re: Geotechnical Review of Grading and Servicing Plans
Proposed Multi-Storey Building Complex
1009 Trim Road, Ottawa
to: Starwood – Martin Chénier - chenierm@live.ca
date: August 20, 2026
file: PG5336-MEMO.06 Revision 2

Grading Plan Review

- ☐ Site Grading Plan – 1015 Tweddle Road Development, Project No. OTT-00259629-A0, Drawing No. C200, Revision 6 dated July 8, 2026

- ❑ Site Servicing Plan – 1015 Tweddle Road Development, Project No. OTT-00259629-A0, Drawing No. C100, Revision 6 dated July 8, 2026

SITE GRADING PLAN

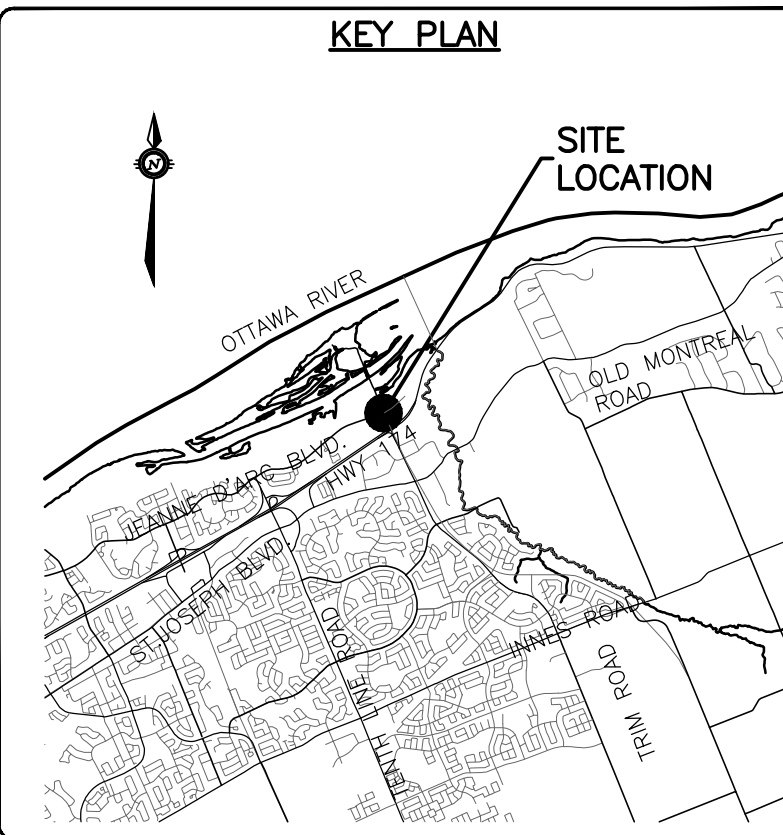
Based on our review of the above-noted drawing, the proposed grades throughout the subject site are mostly within the permissible grade raise restriction of 2 m provided in the aforementioned geotechnical investigation report.

However, some grade raise exceedances were identified in throughout the sloped portion of the development area north of the proposed structure in proximity to the proposed retaining wall structure. This grading and the associated exceedances have been considered in the assessment of the global stability of the proposed retaining wall structure (reference should be made to Paterson Global Stability Analysis memorandum PG5336-MEMO.07 Revision 1 dated March 9, 2026).

Based on that review, lightweight fill (LWF) is recommended to be placed within the backfill of the retaining walls to address the localized exceedances in grading relative to the currently recommended grade raise restriction. Lightweight fill may be assigned across the retaining wall as identified in the *Figure 1 – Proposed Lightweight Fill Plan* attached to this memorandum and as will be detailed and assigned in a manner that is suitably detailed for construction at the time of completing the retaining wall design. The LWF should consist of EPS 12 blocks, with the final thickness profile to be determined following the completion of the retaining wall design. As a general guideline, the thickness of the LWF is expected to range from 1 to 5 m, depending on the area-specific grade raise and geotechnical conditions.

Based on the use of lightweight in those areas, the proposed grading is considered acceptable from a geotechnical perspective. The proposed structure has been provided soil cover for protection against frost action, despite the structure being supported by a deep foundation founded at a significantly greater depth than the buildings excavation.
